DECISION DELEGATED TO HEAD OF PLANNING

Application No: H18-0886-23 **Applicant:** Mr J Robinson & Miss R Hammond

Proposal: Demolition of existing bungalow and erection of detached dwelling - re-submission of H18-0479-23

Location: 110 New Road Sutton Bridge Spalding

Proposed Side (N) Elevation
Scale 1:100

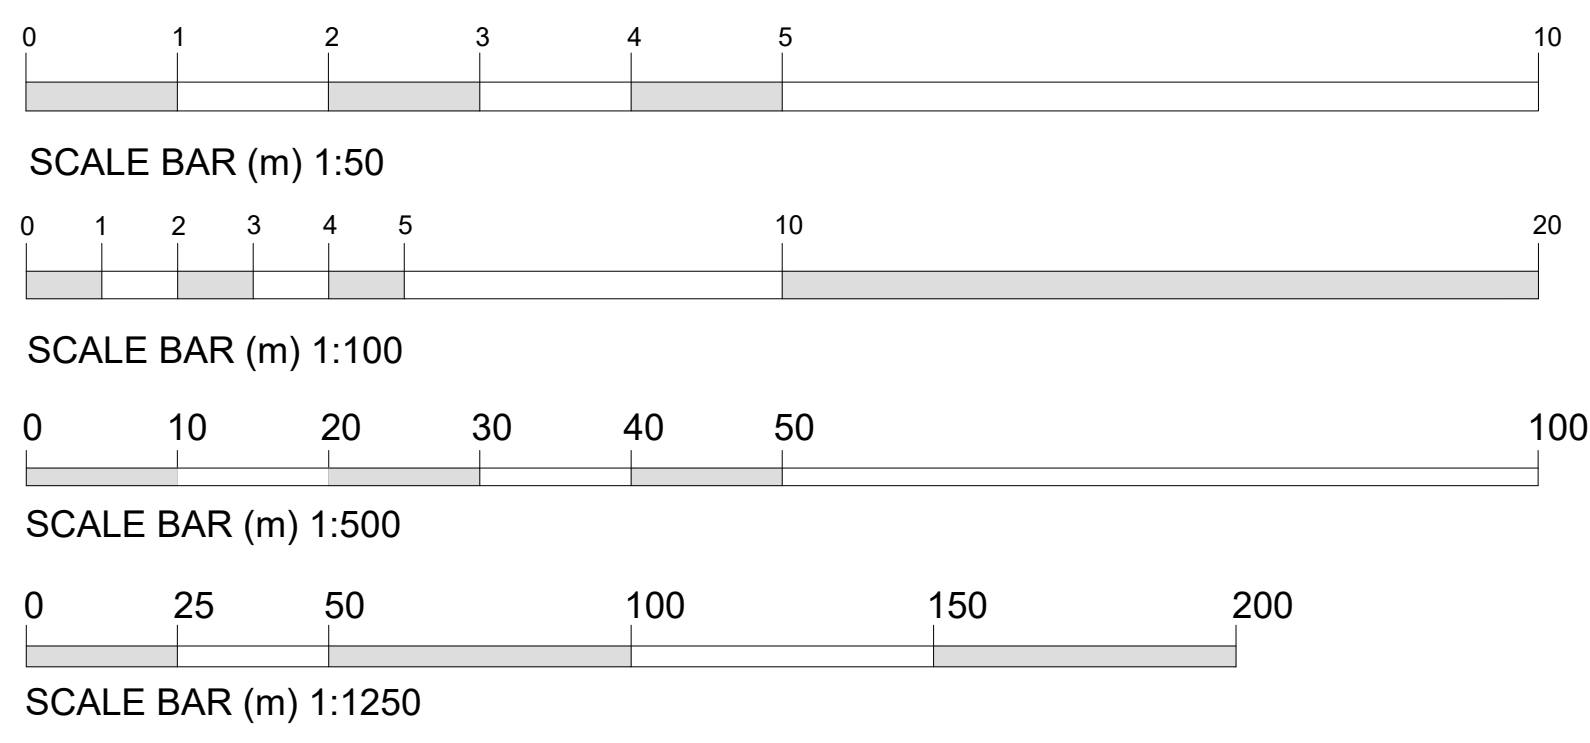
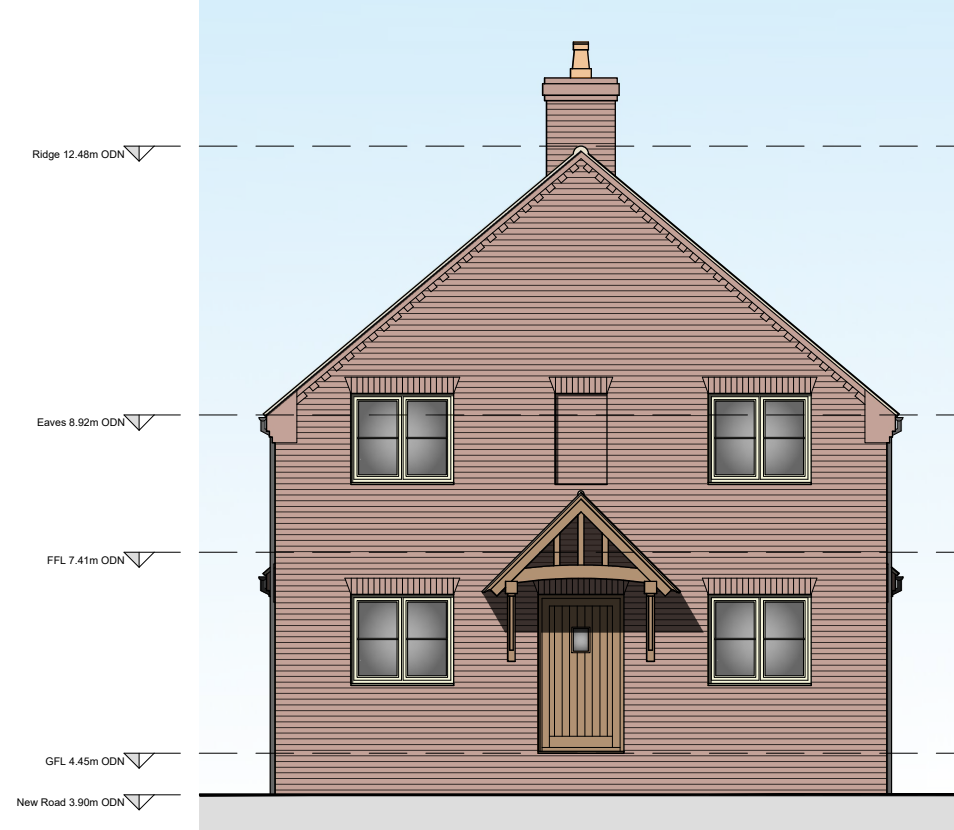
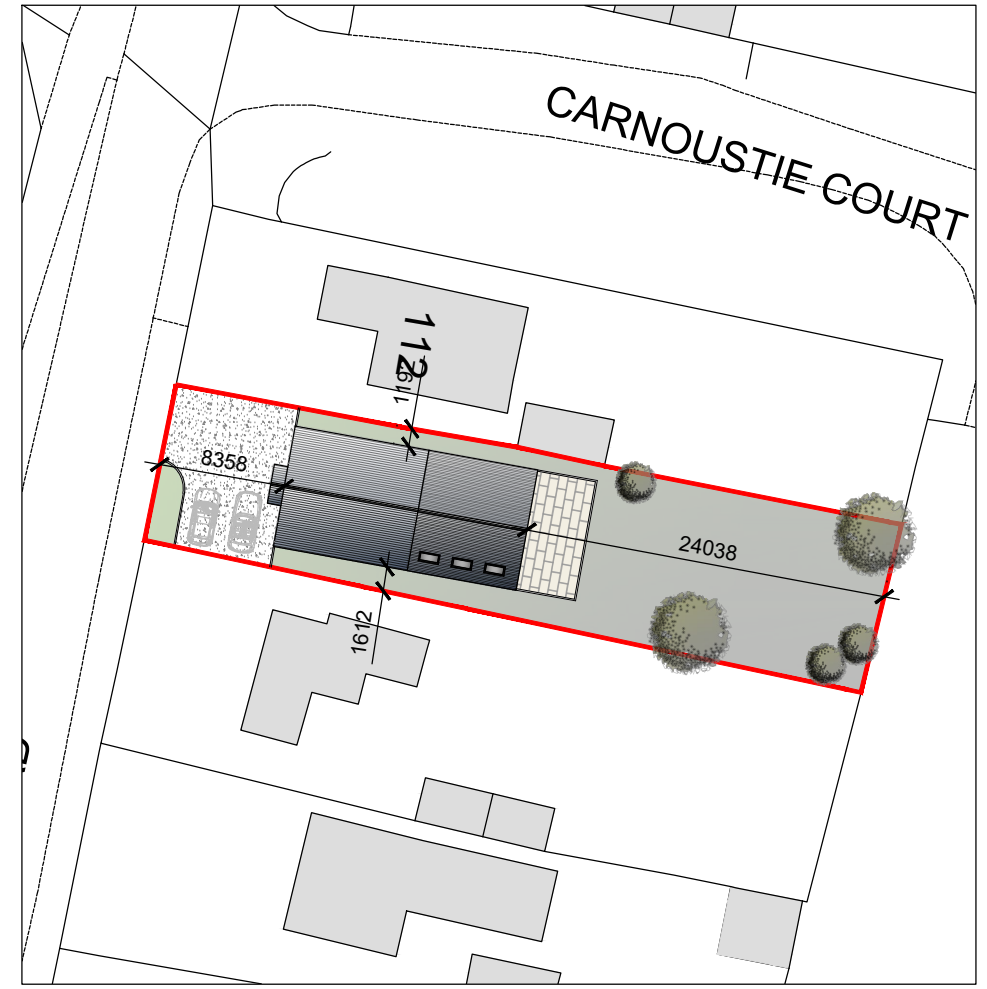
The proposed west elevation (front) includes two windows to the first floor, facing the neighbouring dwellings to the western side of New Road. However, these windows are not considered to have a detrimental impact upon the neighbouring residents through overlooking, as the proposed dwelling (and the front elevational windows) would have a separation distance of approximately 35m (in excess of) from the front elevation of No.87 New Road and a separation distance of approximately 57m from the front elevation of No.83 New Road, as measured from the submitted plans and mapping system, and it is tantamount to a normal frontage relationship.

The proposed south elevation proposes one first floor window, facing No.108 New Road; however, this window is proposed to serve a landing area and staircase, and therefore does not comprise primary living rooms. Therefore, the proposed development will not have a material adverse impact on residential amenity in terms of being causing overlooking or loss of privacy. There are also no first floor windows on No.108 New Road, facing onto the new proposed dwelling. The neighbouring property lies immediately south of the proposal and therefore, would not be unduly impacted by a loss of light or overbearing impact; further, the resultant relationship is not at odds with existing development along the wider area of New Road.

The proposed north west elevation has two proposed first floor window however, it is considered that the proposed windows will not have a detrimental impact upon overlooking, as the dwellings to the rear of the site are approximately 34m away.

The proposed north elevation proposes a first window, facing No.112 New Road, with this property being that which immediately neighboured the proposed development. However, this window is proposed to serve a bathroom and is likely to be obscure glazed. As such, the proposed development will not have a material adverse impact on residential amenity, in terms of creating overlooking or loss of privacy.

However, notwithstanding the points raised, predominantly in respect of overlooking and privacy, the proposed development would result in an increase in built form immediately neighbouring No.112, which would be immediately north of the proposed dwelling, resulting in an unacceptable loss of outlook and loss of light to principal windows. No.112 has a first floor window facing the proposed dwelling, and although there seems to be another window serving this first floor room to the west elevation, the siting of the proposed dwelling within the plot means that the proposed dwelling would be forward of this elevation and would clearly be visible from the front windows of No.112, further increasing the impact to the neighbouring dwelling. Further, the marked increase in scale of the built form, and the resultant 'bulk' of development is considered to cause an unacceptable impact to the residential amenities of current and future occupiers of this neighbouring property.
